KITITAS COUNTY

DEPARTMENT OF PUBLIC WORKS

SUBJECT: LPF-22-00004 Suncadia Phase 2 Division 7 Final Plat Comments

DATE: 2022-06-29 JOB NO. 998-852-021-0003
DRAWN BY: C.A.F./R.F.G. SHEET 4 OF 15

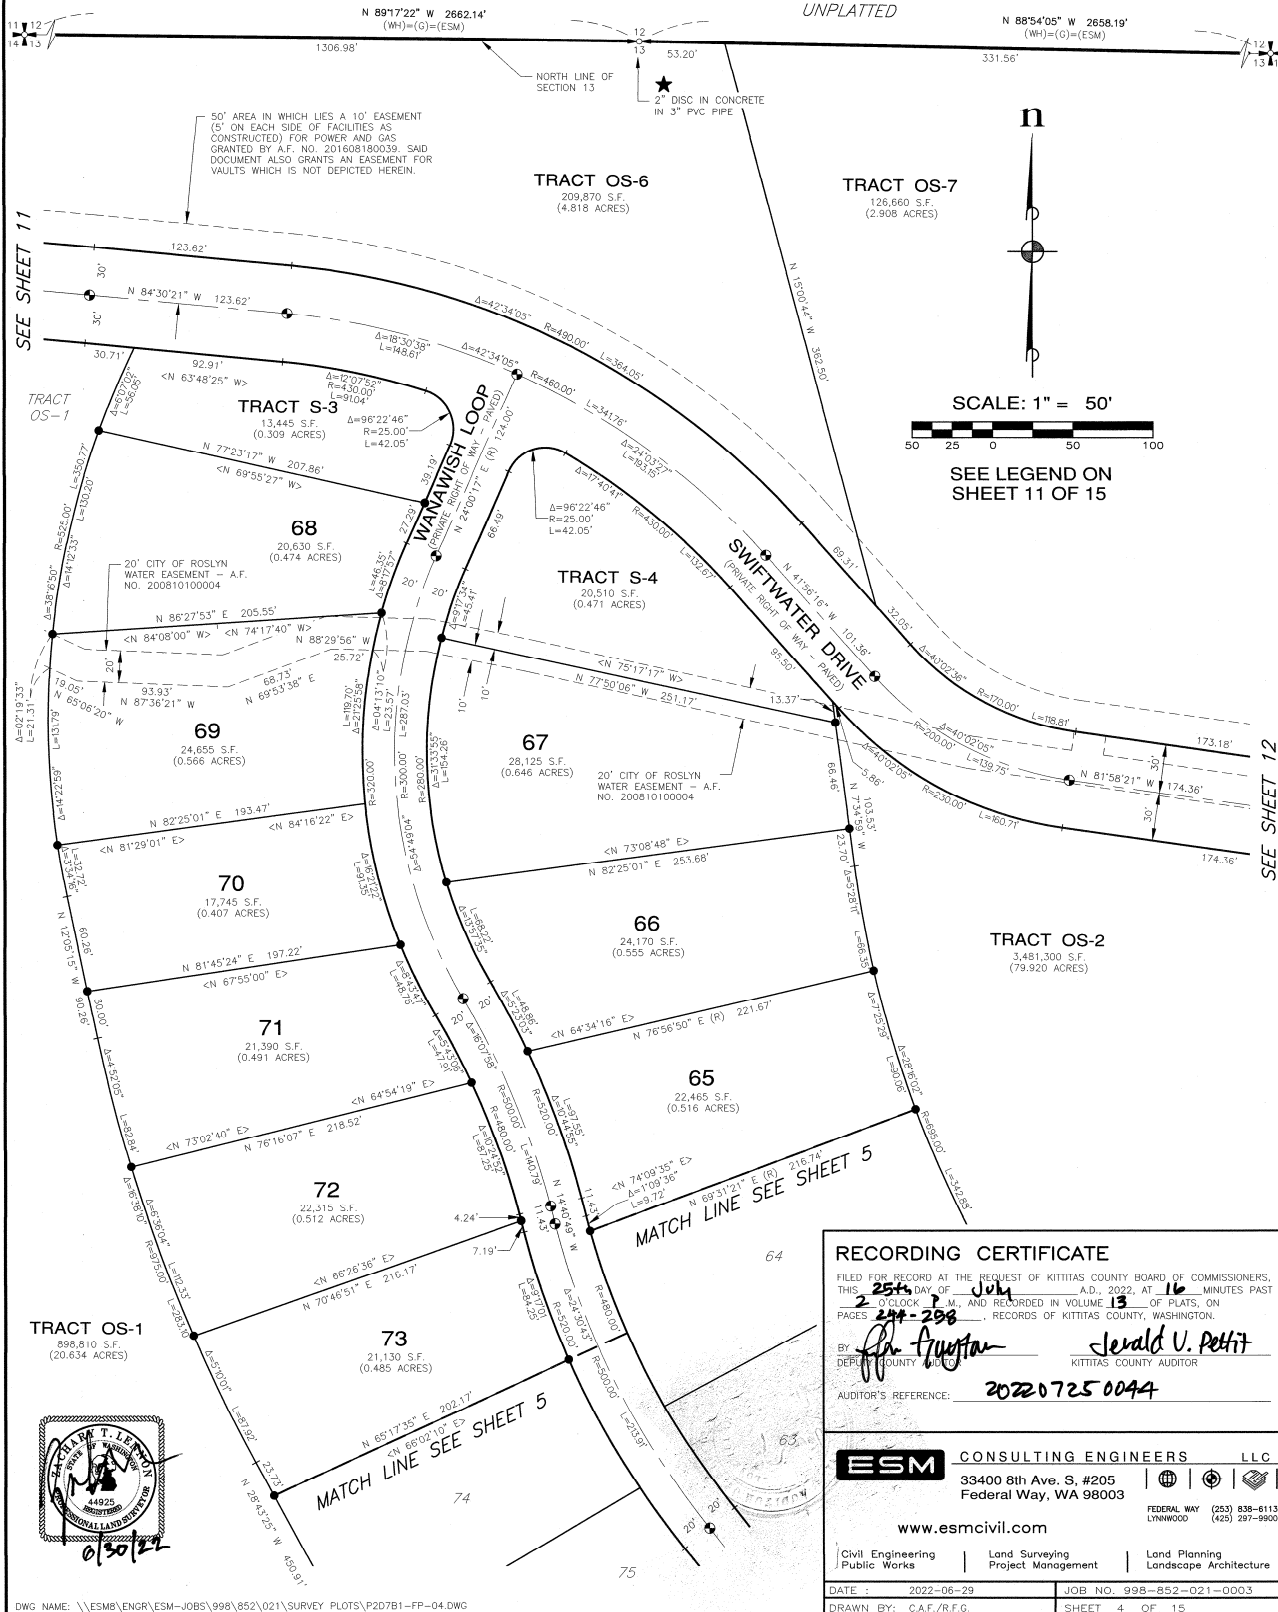
1. Sheet 4 – The North line of NW ¼ of Section should show a “tick mark” to show the line limits.
2. Sheet 4 - The North line of OS-7 should show a bearing. While this is available on other sheets, it is somewhat difficult to find.
3. Sheet 6 – The area of Lot 81 does not match the Lot Closure report.
4. Sheet 9 – The area of Lot 7 does not match the Lot closure report.
5. Sheet 10 – The area of Lot 11 does not match the closure report.
6. Sheet 11 – Please label Tract OS-2 on this sheet.

Civil Engineering Public Works	Land Surveying Project Management	Land Planning Landscape Architecture
DATE: 2022-07-11	JOB NO. 998-852-021-0003	
DRAWN BY: C.A.F./R.F.G.	SHEET 13 OF 15

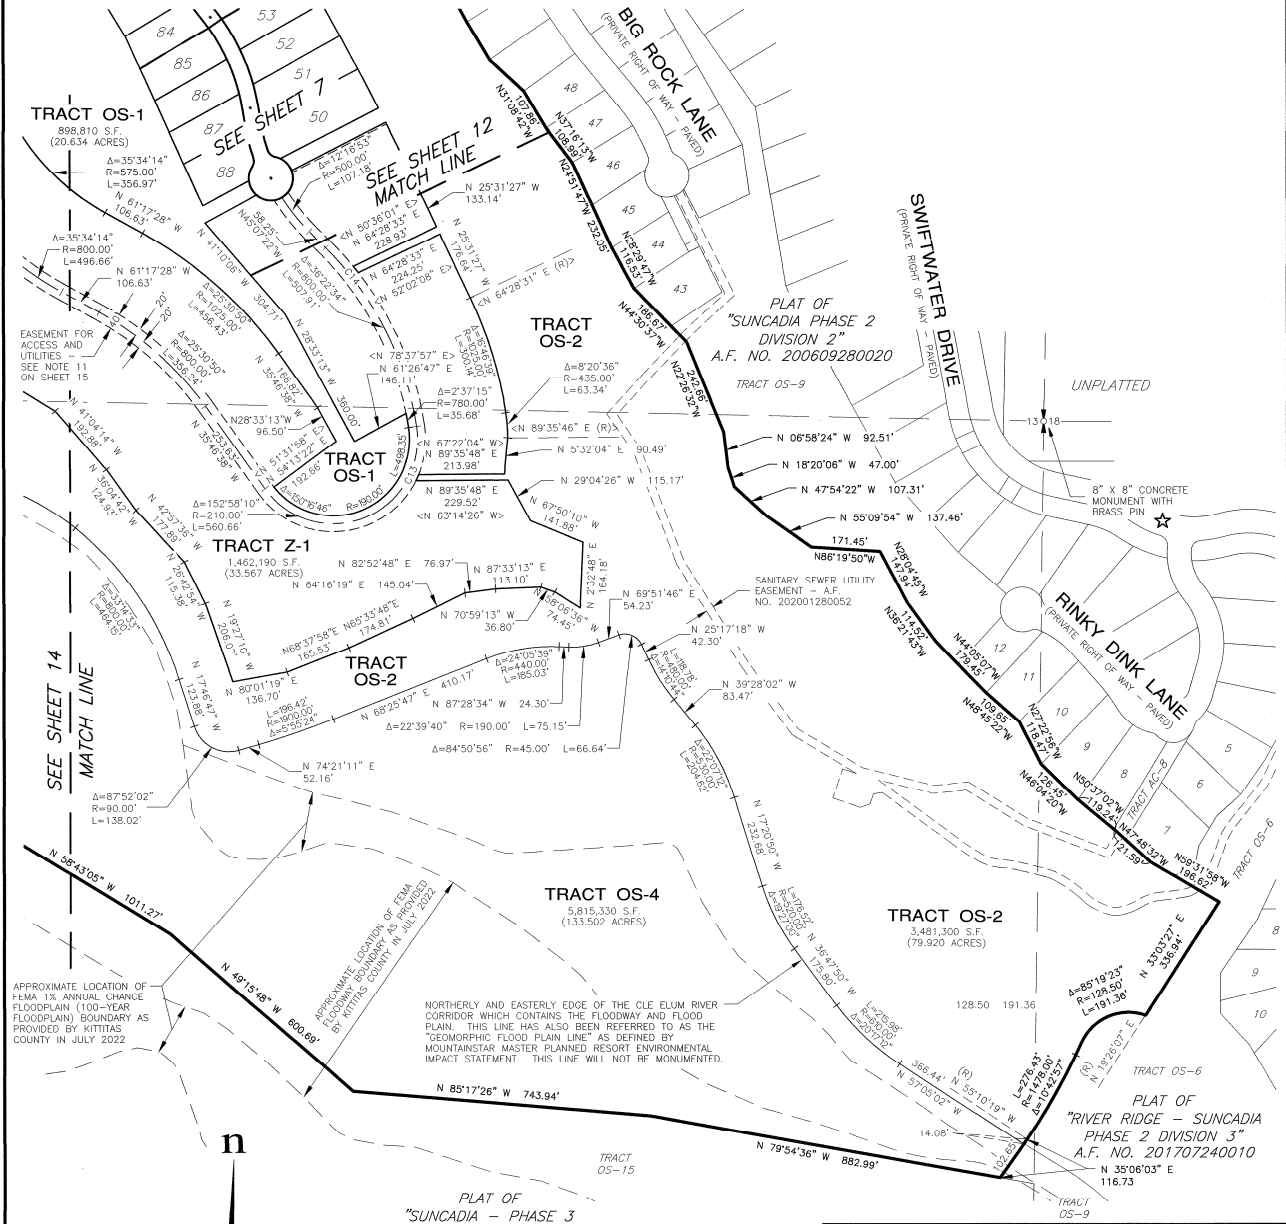
Floodplain development requirements for LPF-22-00004 have not been met. In accordance with KCC Chapter 14.08.220(5), all subdivisions shall show on the face of both the preliminary and final plat, for either short or long plats, the boundary of the 100-year floodplain and floodway.
